Please ask for: Nicola Moore
Email: nicola.moore@arun.gov.uk
Telephone: Ext 37944
Our Ref: AW/140/22/CLP
Your Ref:
Date: 31st May 2022

Lawful Development Certificate for a Proposed Use or Development

Development: Lawful development certificate for a proposed single storey rear extension.
Location: 15 Bradlond Close Aldwick PO21 2RQ

Block Plan
Scale 1:500

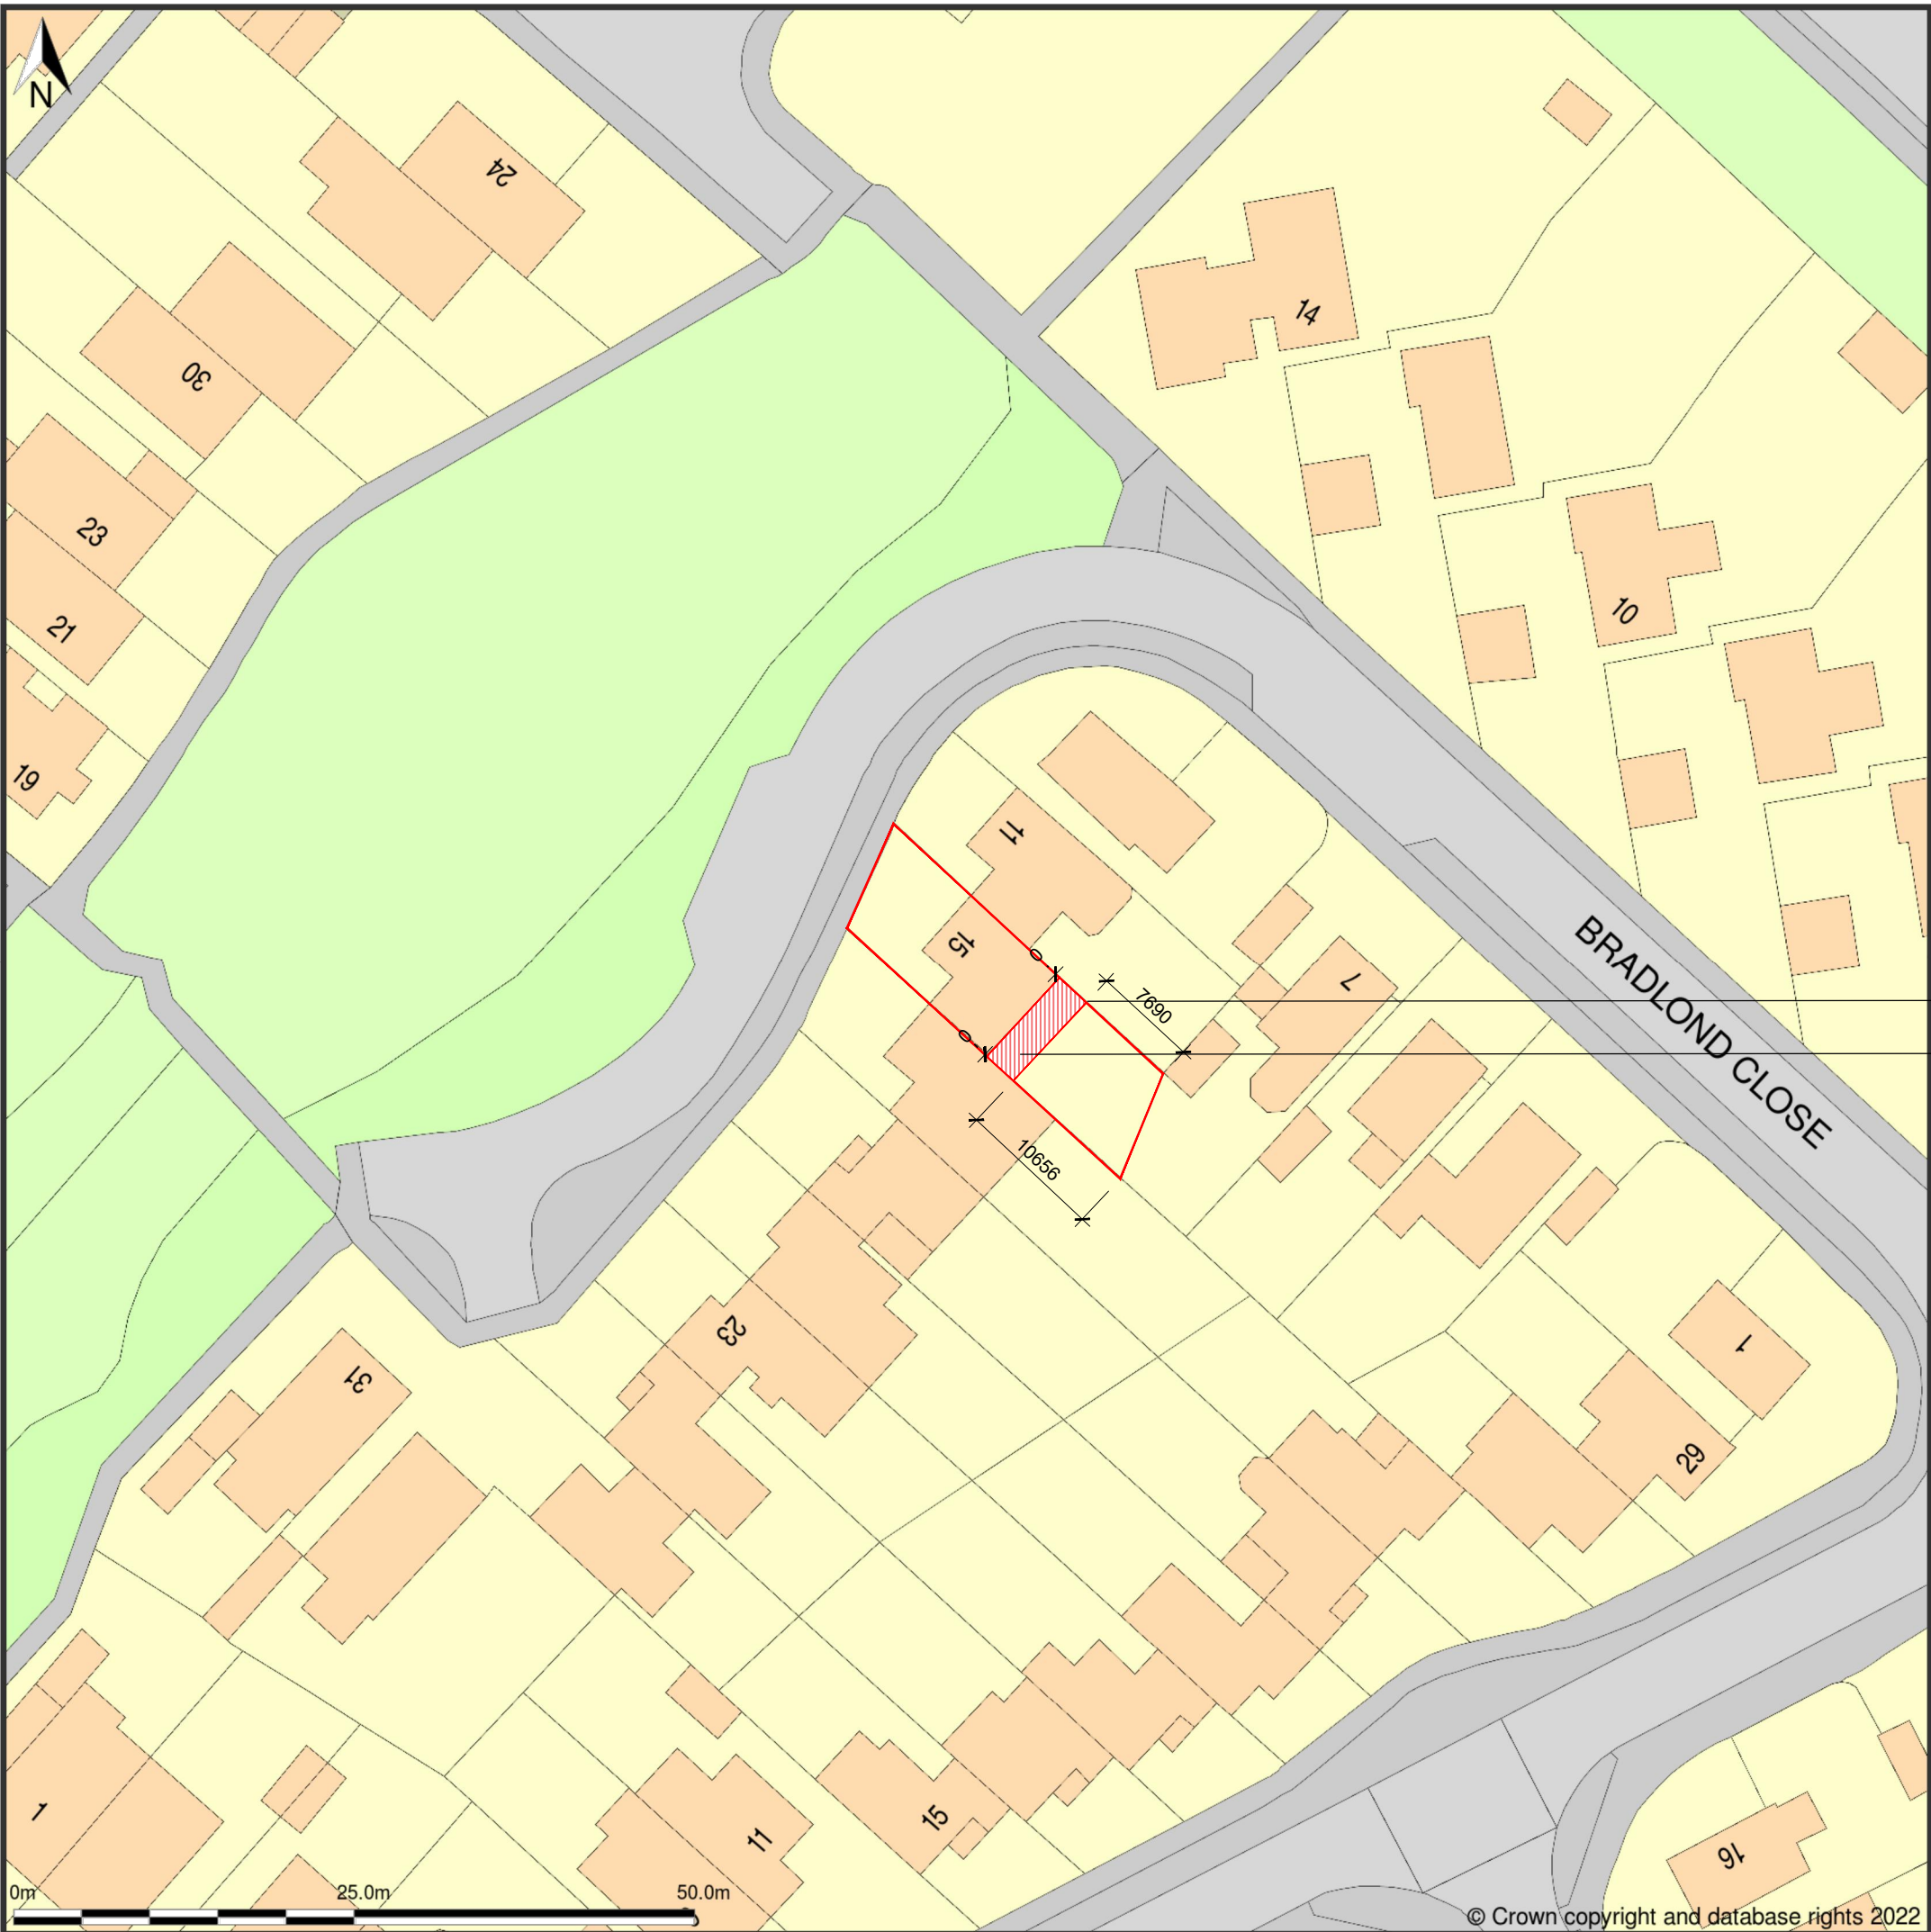
The Block Plan should include distances to the boundary from the proposed development. Please amend accordingly and re submit.
